Project Title: Blvd 2500 **Building Permit #** _____ **Hydrology File #** _____
DRB# PR-2018-00158 **EPC#** _____
Legal Description: TRS 1 2 & 3 Unit 1 Together w/TRS 4 5 & 6A Unit 2
Dale J Bellamahs Carlisle Replat & Lot 22A Plat of Lt 22A City Address OR Parcel 2500 & 2412 Carlisle Blvd NE
Blk 22 Timoteo Chavez Addition & Port of BLKS N & O Timoteo Chavez Addition

March 21, 2023

**RE: RESPONSE TO CONCEPTUAL TRAFFIC CIRCULATION LAYOUT COMMENTS
BLVD 2500
NE CORNER OF CARLISLE BLVD & CUTLER AVE**

MOTORCYCLE PARKING SIGN
NTS

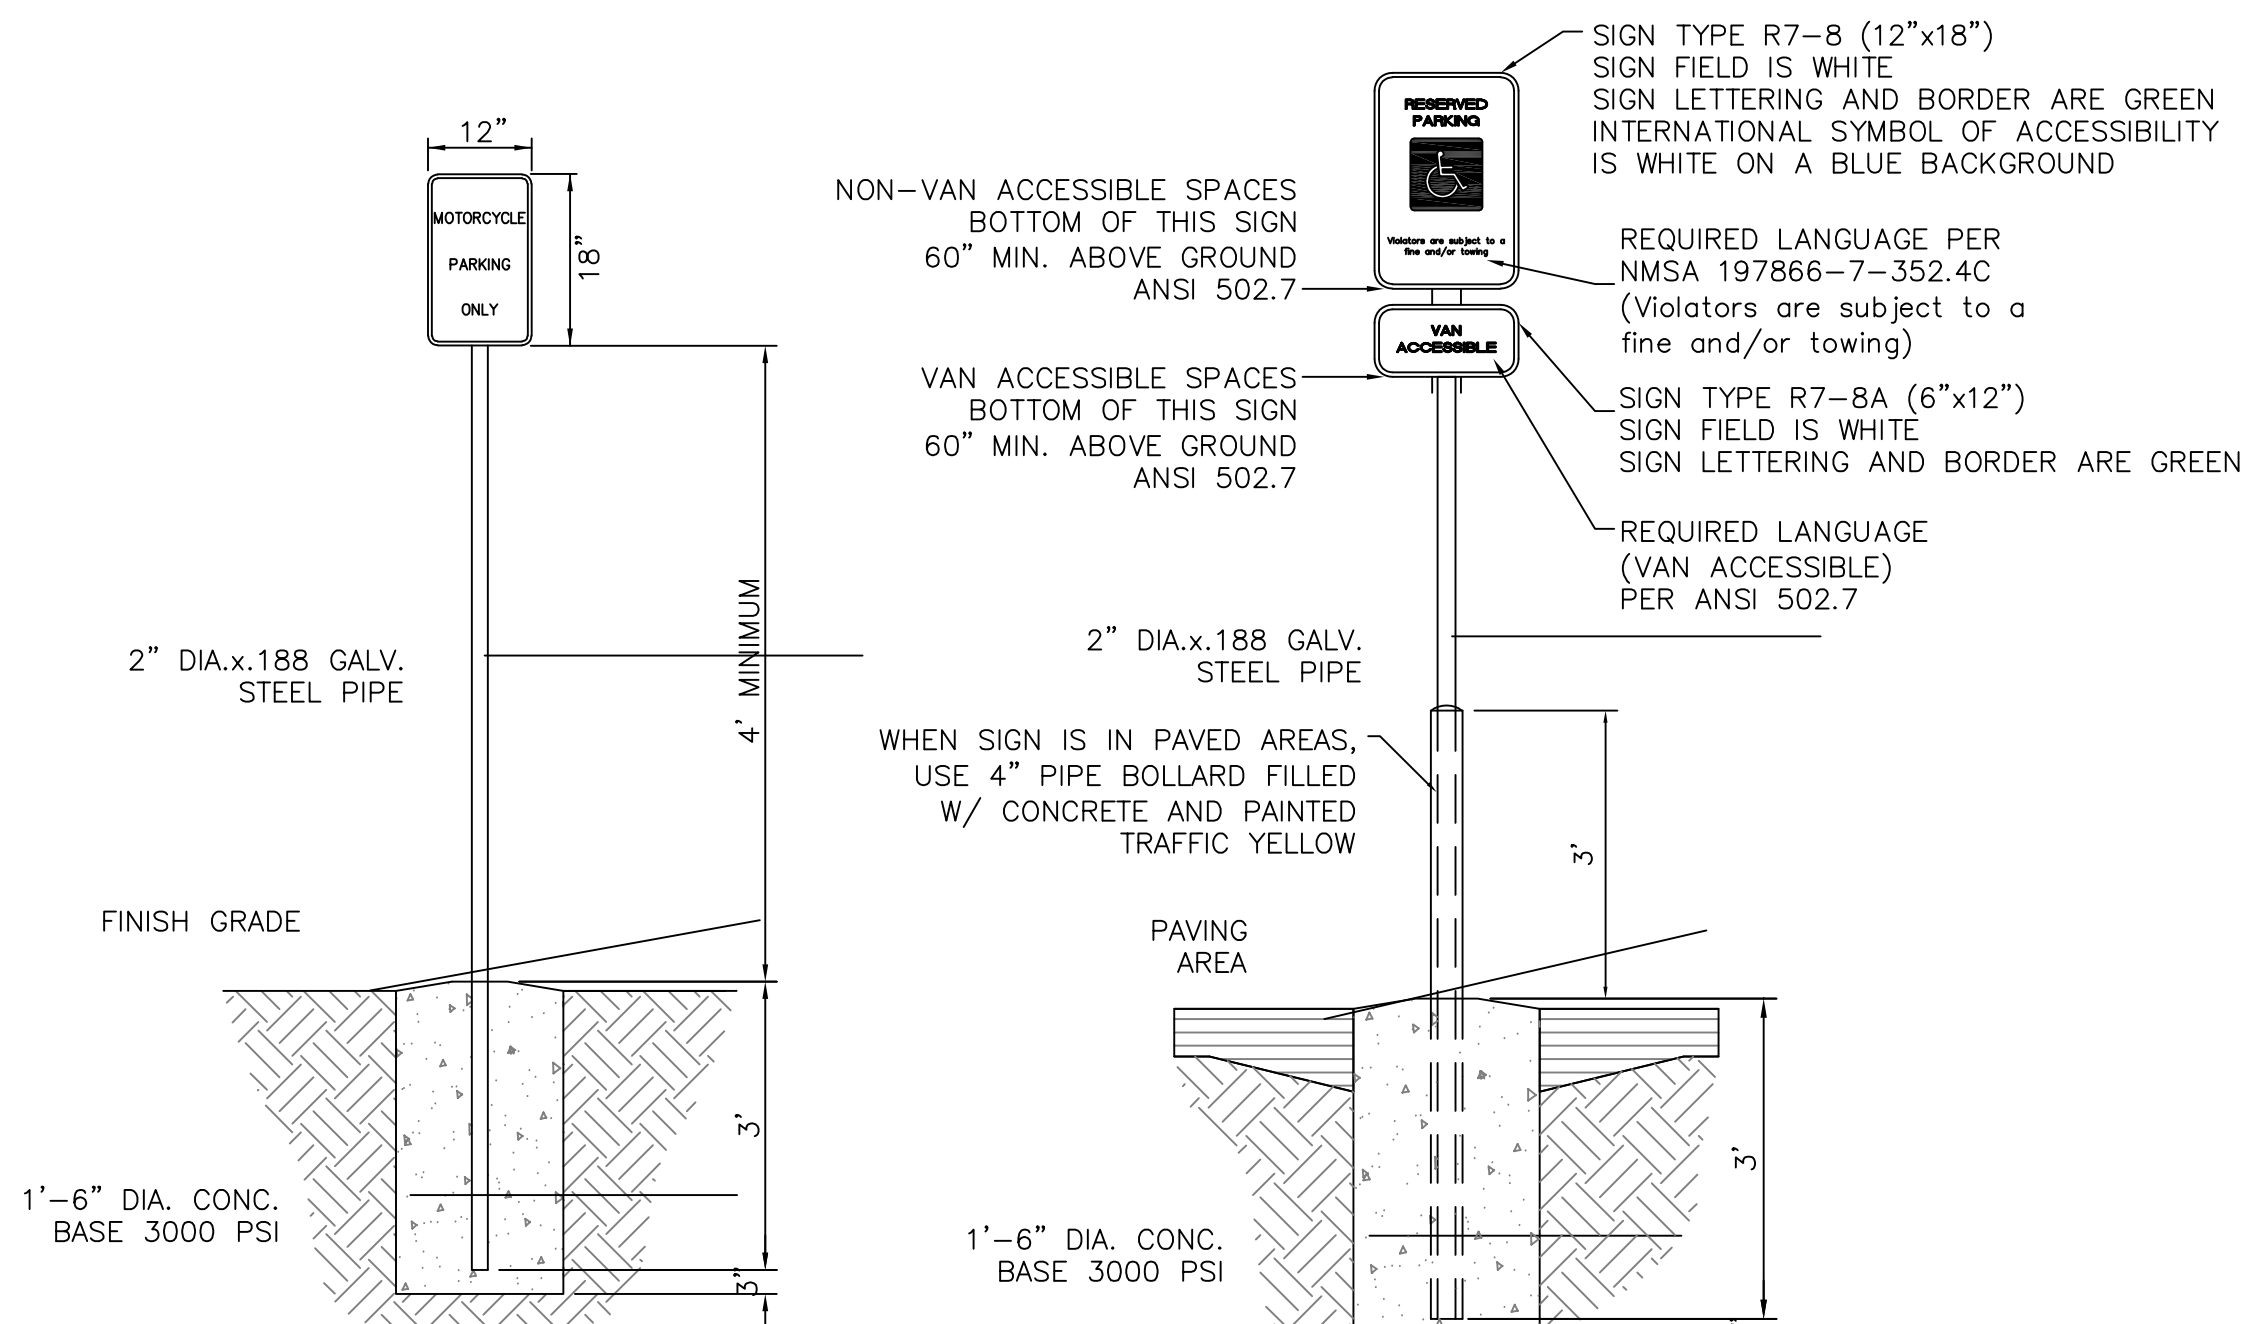
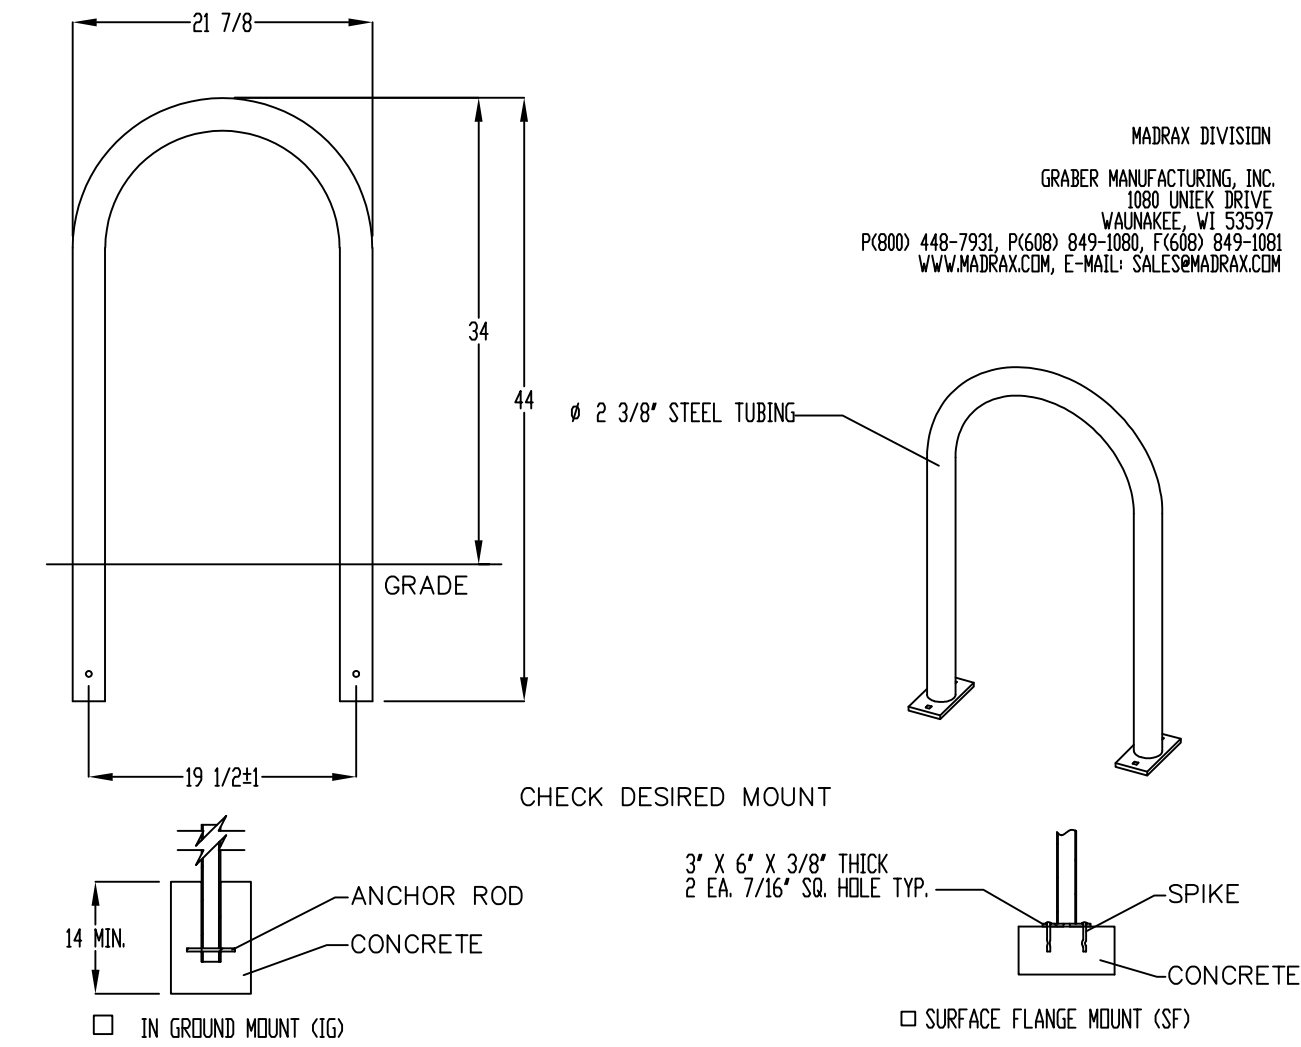
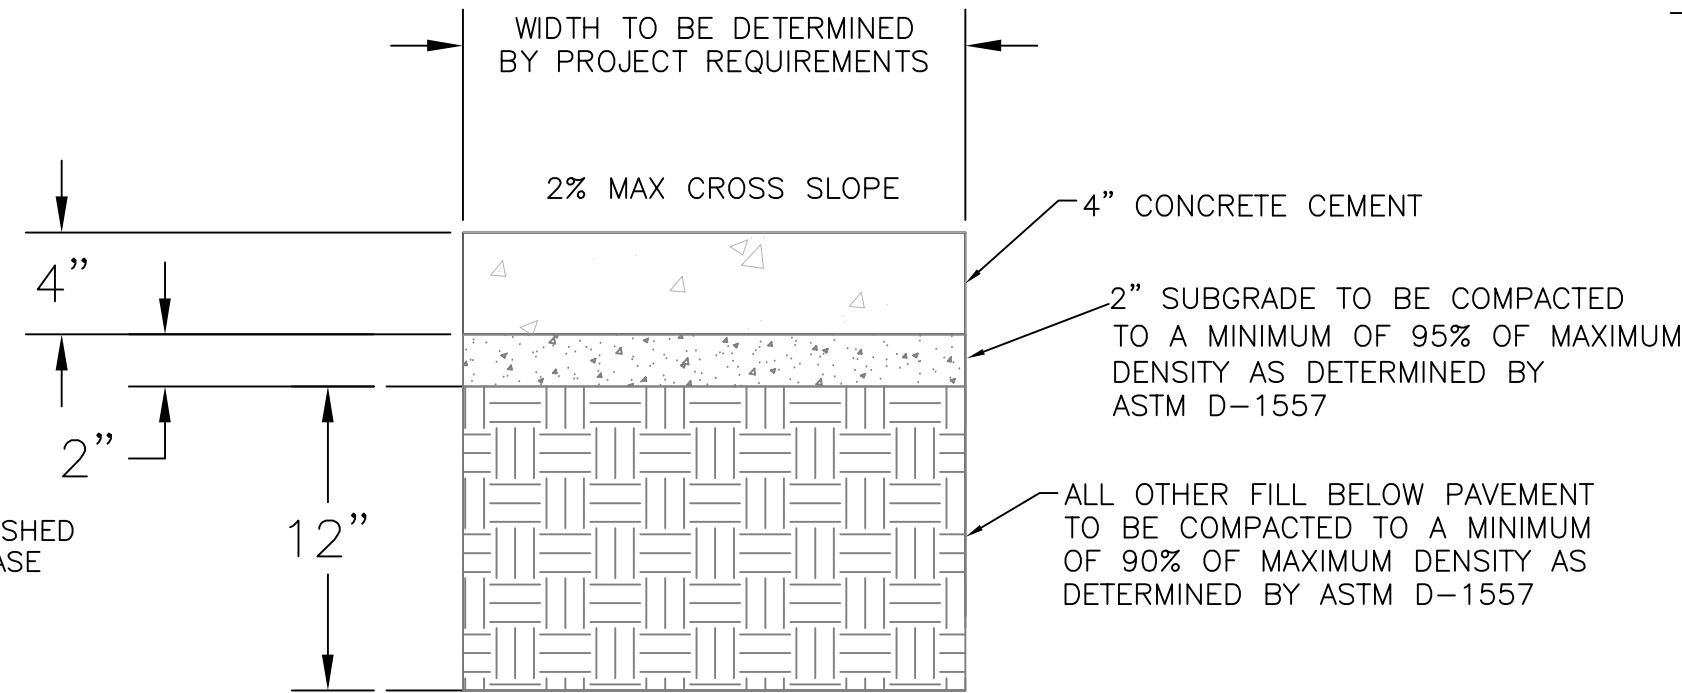
3. Provide Motorcycle parking space posted upright sign, either free standing or wall mounted per the zoning code.
RESPONSE: Keyed note 6 mentions motorcycle parking space w/ sign. A free standing sign detail can be found on Sheet C1.2.

6. Motorcycle parking spaces shall be designated by its own conspicuously posted upright sign, either free-standing or wall mounted per the zoning code.

RESPONSE: Keyed note 6 mentions motorcycle parking space w/ sign. A free standing sign detail can be found on Sheet C1.2.

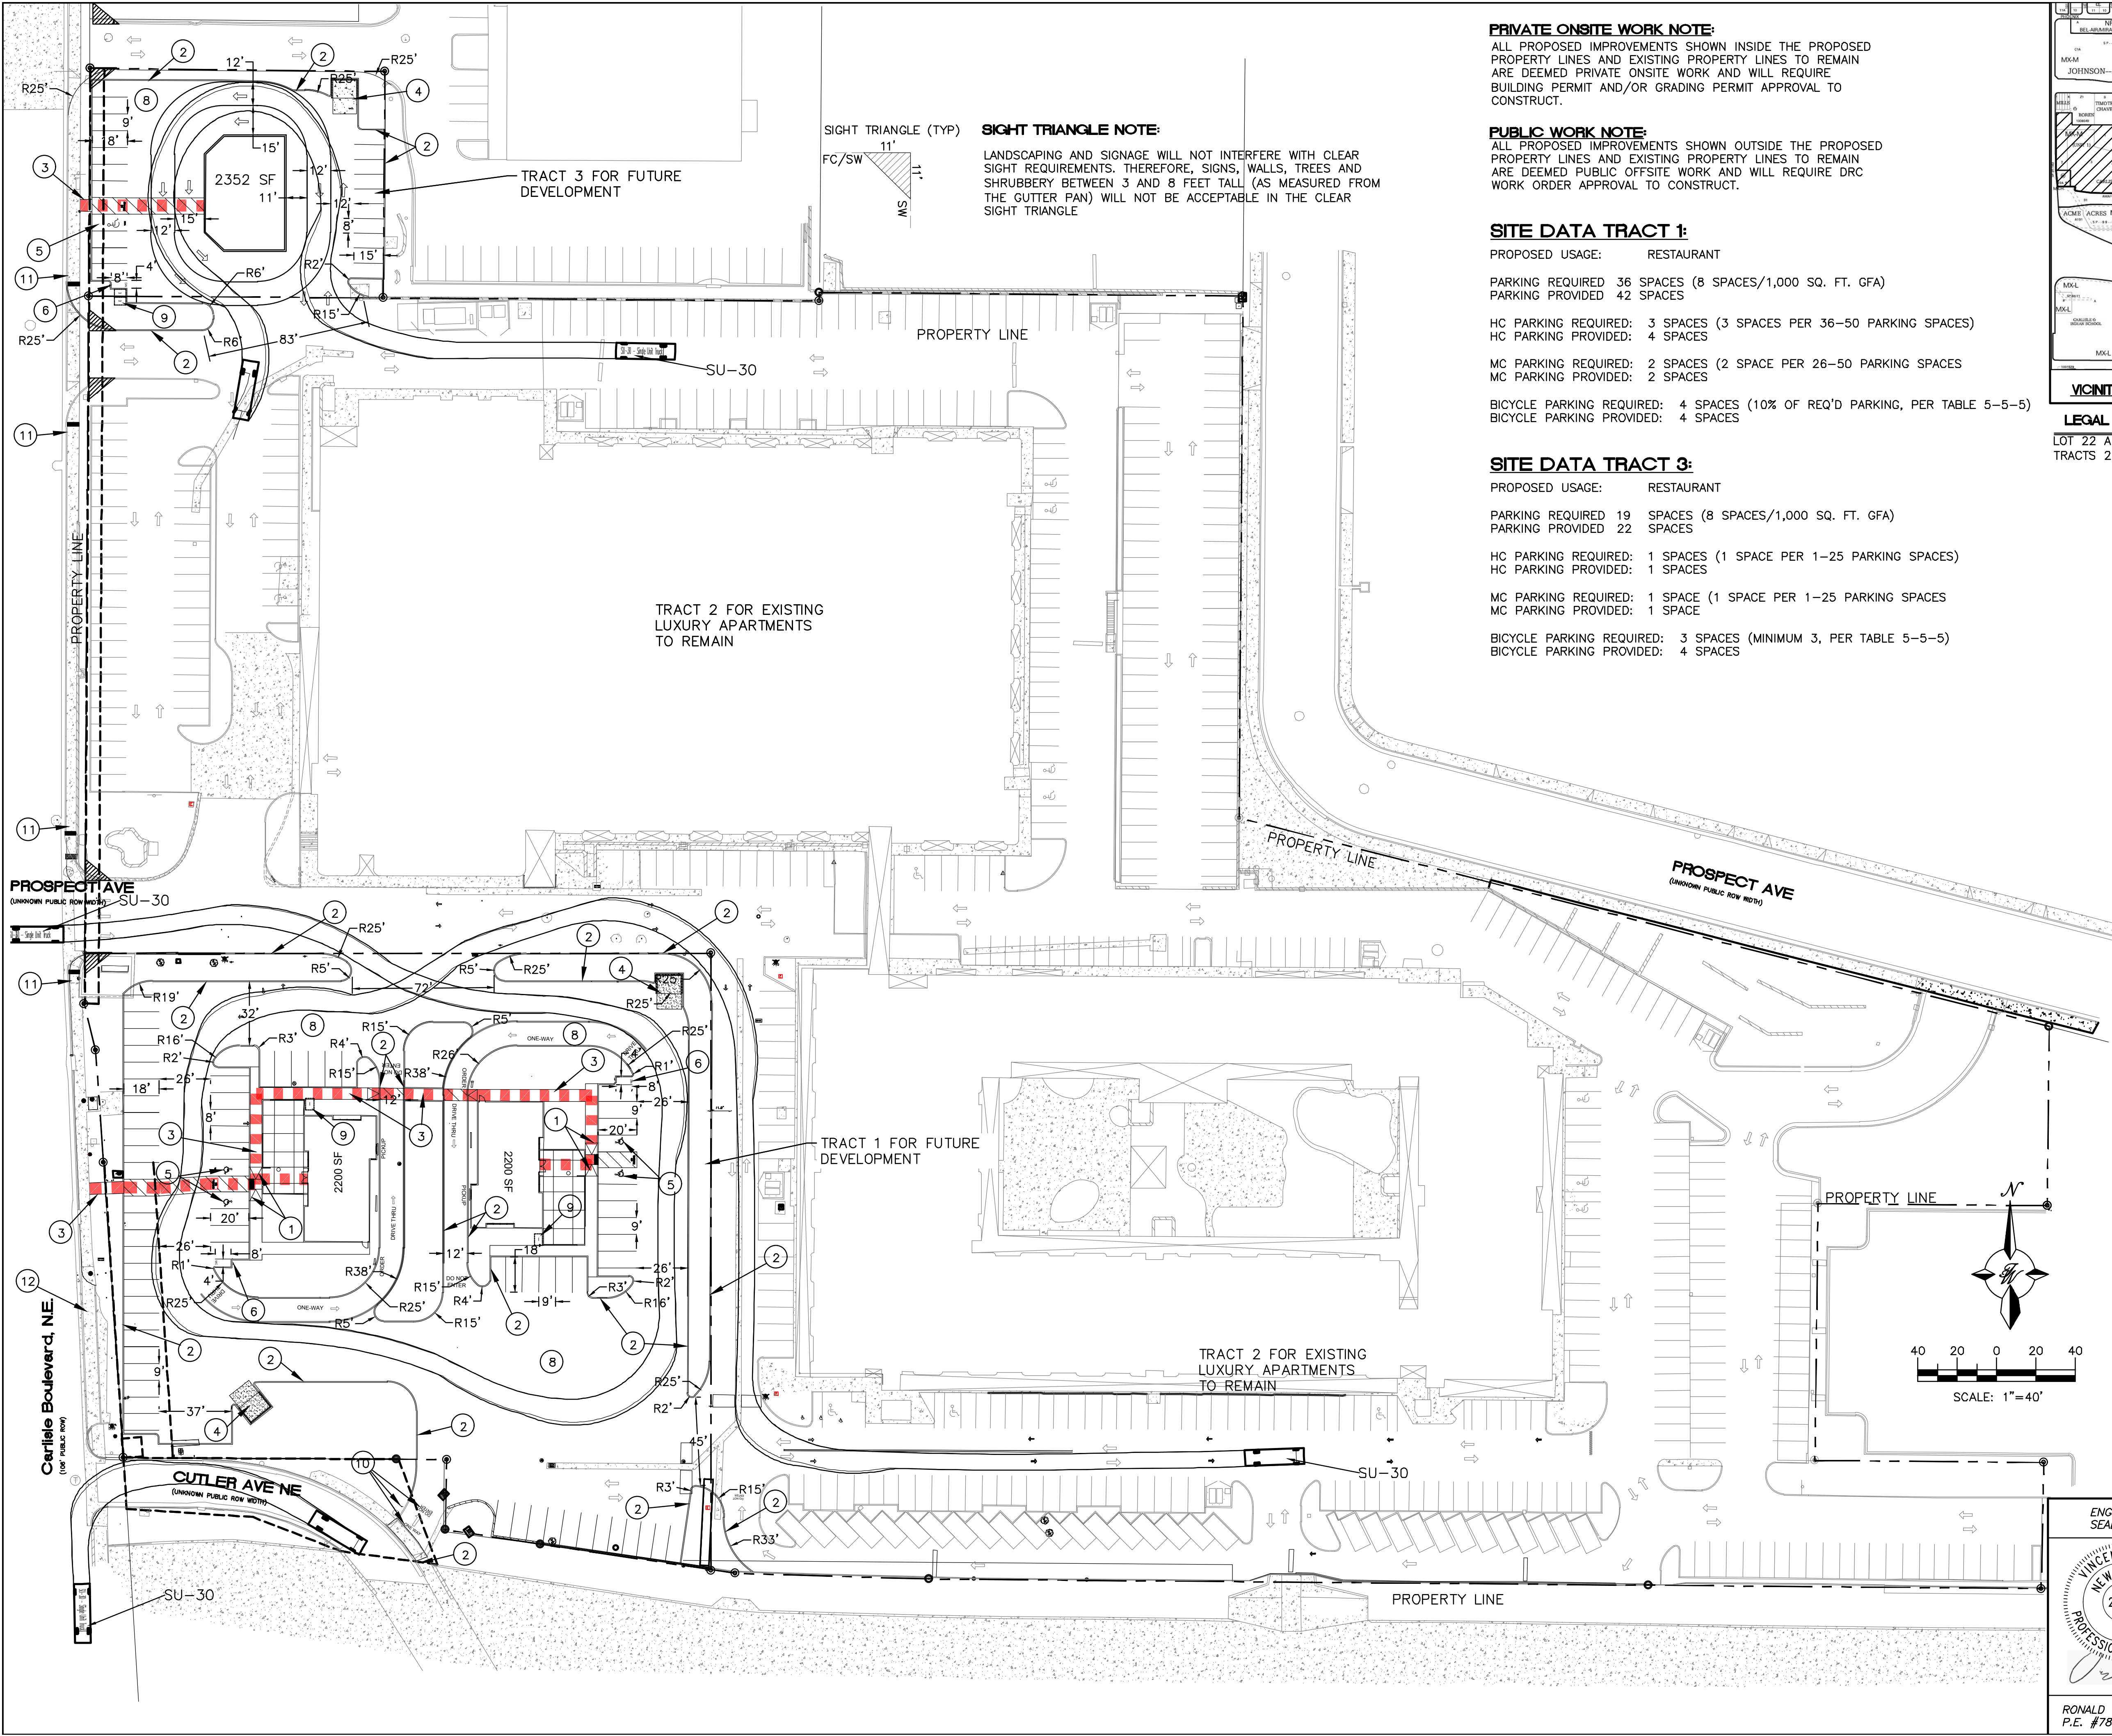
1. List the number of bicycle spaces required by the IDO.
RESPONSE: Required and provide bicycle spaces are shown under the "Site Data". Bike racks have also been added and called out with keyed note 9.

2. Grades and slopes in the parking area and/or the ADA Accessible parking areas appear to be too large. Please provide more detail.
RESPONSE: The proposed grading plan for the property was reviewed to show that all of these ADA parking areas do not exceed 2% in any direction. Keyed note 5 has been updated to stated 2% max slope in any direction.

4. Please clarify, is the site access off Cutler ONE Way? If so, please provide "ONE WAY" sign and pavement marking.
RESPONSE: The access off Cutler is one way. "ONE WAY" and "DO NO ENTER" sign and pavement markings are shown and called out as Keyed Note 10.

5. ADA Curb ramps for site accesses along Carlisle must be updated to current standard and have truncated domes installed.
RESPONSE: ADA unidirectional ramps w/ truncated domes are now shown along Carlisle to be removed and replaced and called out with Keyed Note 11.

7. Per the IDO, a 6 ft. wide ADA accessible pedestrian pathway is required from the public sidewalk to the building entrances. Please clearly show this pathway and provide details.

RESPONSE: A 6' wide pathway is highlighted in red to show ADA access from the public sidewalk to each building.
8. Per the IDO, a 6 ft. wide ADA accessible pedestrian pathway is required from the ADA parking stall access aisles to the building entrances. Please clearly show this pathway and provide details.

RESPONSE: A 6' wide pathway is highlighted in red to show ADA access from the Parking to each building.
9. It is not apparent what type of pavement surface is being proposed. A hard driving surface will be required as part of this proposed project for parking area and drive aisles.

RESPONSE: Keyed Note 8 calls for Private onsite asphalt pavement, with pavement section to follow Geotech report.
10. The proposed drive-thru lanes: all one way drives shall have "One Way" and "Do Not Enter" signage and pavement markings. Please show detail and location of posted signs and striping.

RESPONSE: "One Way" and "Do Not Enter" signage and pavement markings are shown on the plan for the drive-thru lanes.
11. Show the intersection clear sight triangle at the north side site access off Carlisle Blvd.
